**Consultation Response from KC, Conservation and Design**
**2021/93443 Coffee Novo, 50, New Street, Huddersfield, HD1 2BW**
**Listed Building Consent for change of use of first and second floor to form 3 apartments with associated internal and external works (Within a Conservation Area)**
**Date Responded: 9.6.22**
**Responding Officer: Sue Brooks**
**Responding Ref:**

PROJECT		
Cafe, Huddersfield		
SHEET		
Proposed Plan		
CLIENT		
I Sidyot		
Project number	Scale (@ A3)	
552	1 : 100	
DRAWING No	Date	REV
10	08/08/20

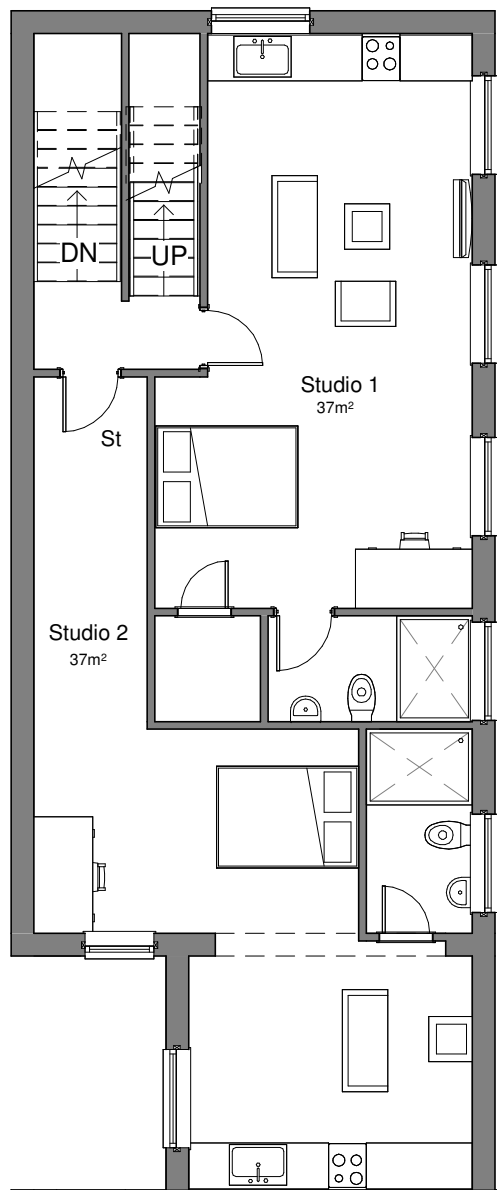
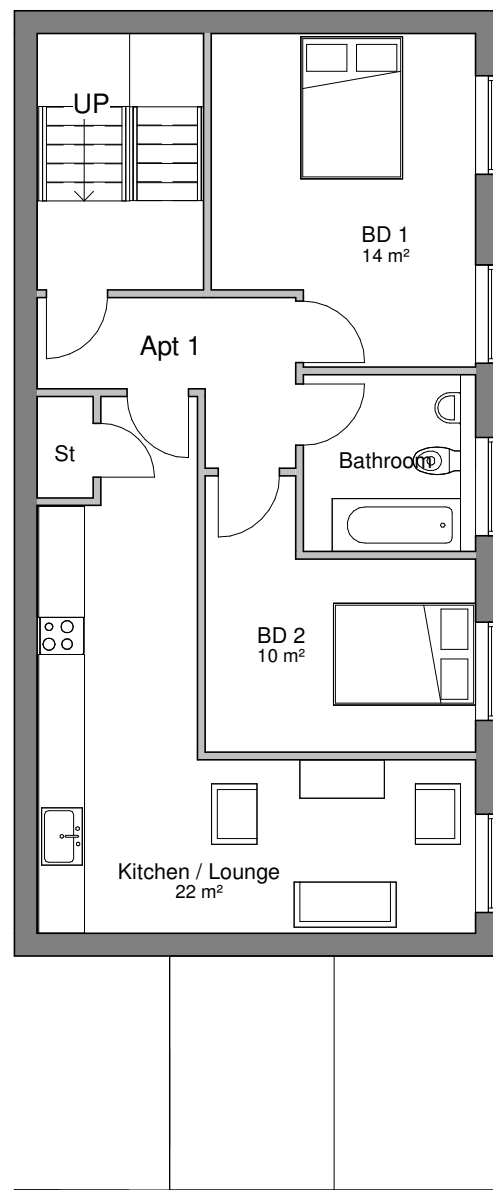
The only external alteration proposed is a small uPVC window to match the existing. However, there is no proposed elevation drawing showing the location of this and the first and second floor plans indicate that two windows are proposed on the east facing gable. The insertion of new windows at both levels is acceptable, however the windows must be timber framed and in a similar style to the existing traditional windows in the building. Full details, including 1:20 window elevations and 1:5 window sections will need to be submitted by condition. The windows shall be timber framed, set into the reveals by 100mm, and within natural stone surrounds to match the existing on the north elevation.

- The proposal to retain the existing windows should be considered further as detailed above.
- Details of proposed new windows need to be amended and submitted.
- Details and internal sections must be submitted to demonstrate that internal historic details such as trusses and fireplaces are retained and incorporated into the proposal.

- details of the proposed new windows to be submitted for approval, as described above.
- retain and restore existing windows and provide details of proposed repairs and treatments.
- Provide details of how the historic internal features will be incorporated into the proposal.

Existing Plans

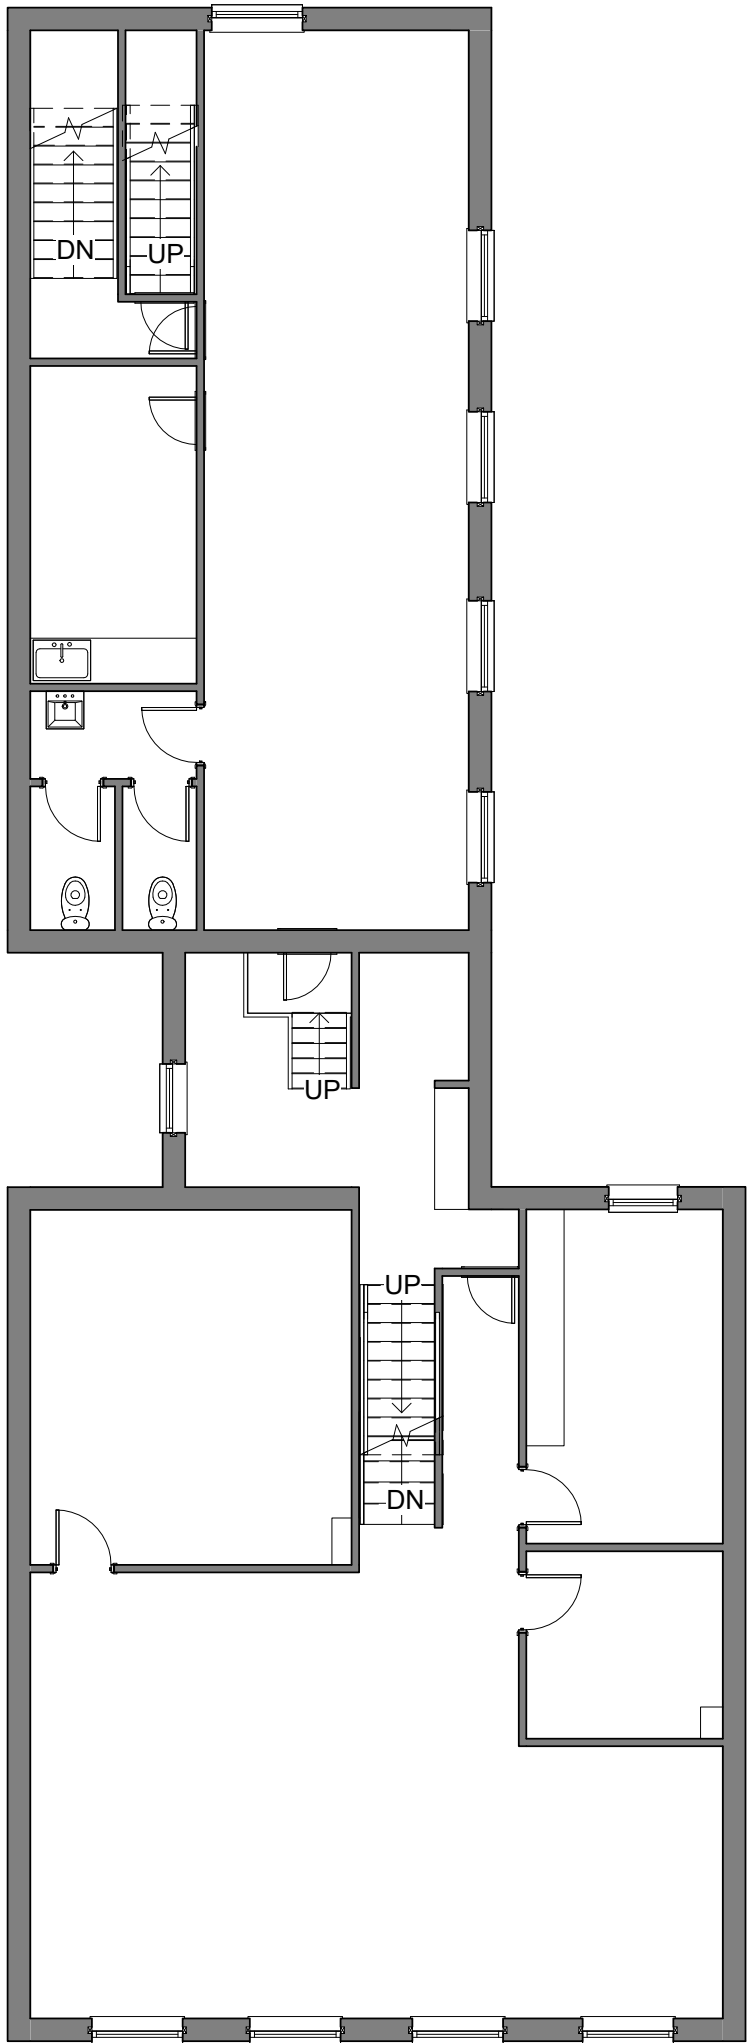
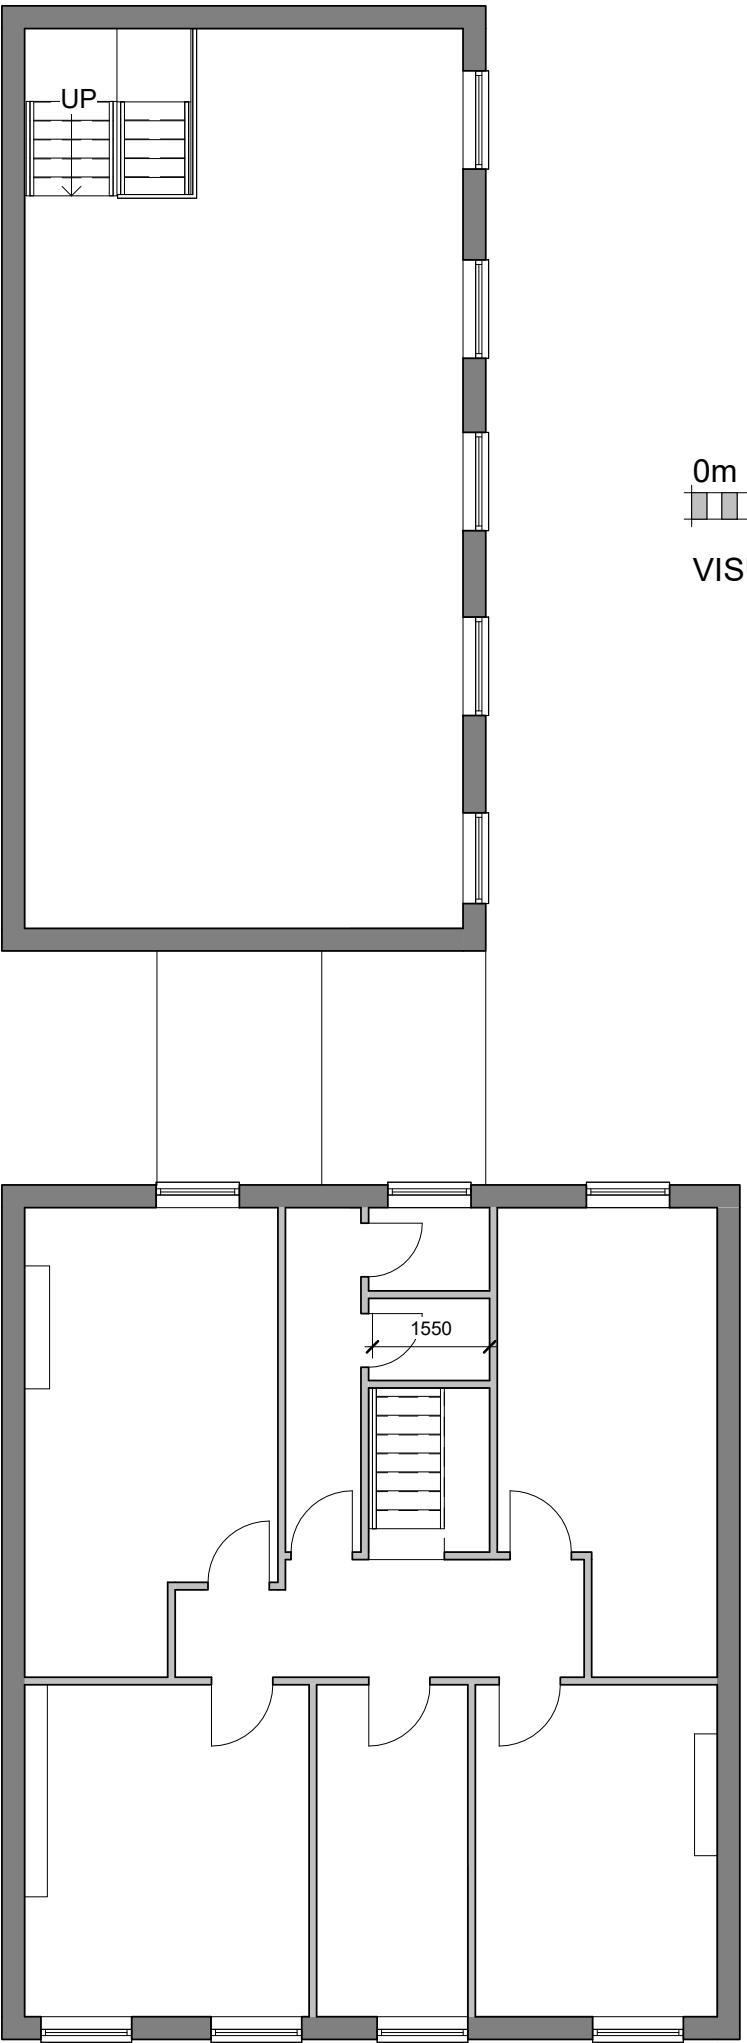
The application shows the proposed retention of the existing windows on the first and second floors.

The existing timber framed multi-paned fixed light and sash windows must be retained and restored, with any restored details matching the existing details.

However, these are single glazed windows, piecemeal with some later replacements and some are in poor condition. There are fixed lights in habitable rooms and clear glazing in the proposed bathrooms. We would recommend that the treatment of the windows is considered further as part of this application.

Replacement windows, the introduction of opening lights, double glazing or obscured glass will require listed building consent. If, following further consideration, their replacement is considered necessary, evidence and justification must be provided to show that they cannot be retained, along with full details of the proposed replacements. Full details including 1:20 window elevations and 1:5 window sections will need to be submitted.
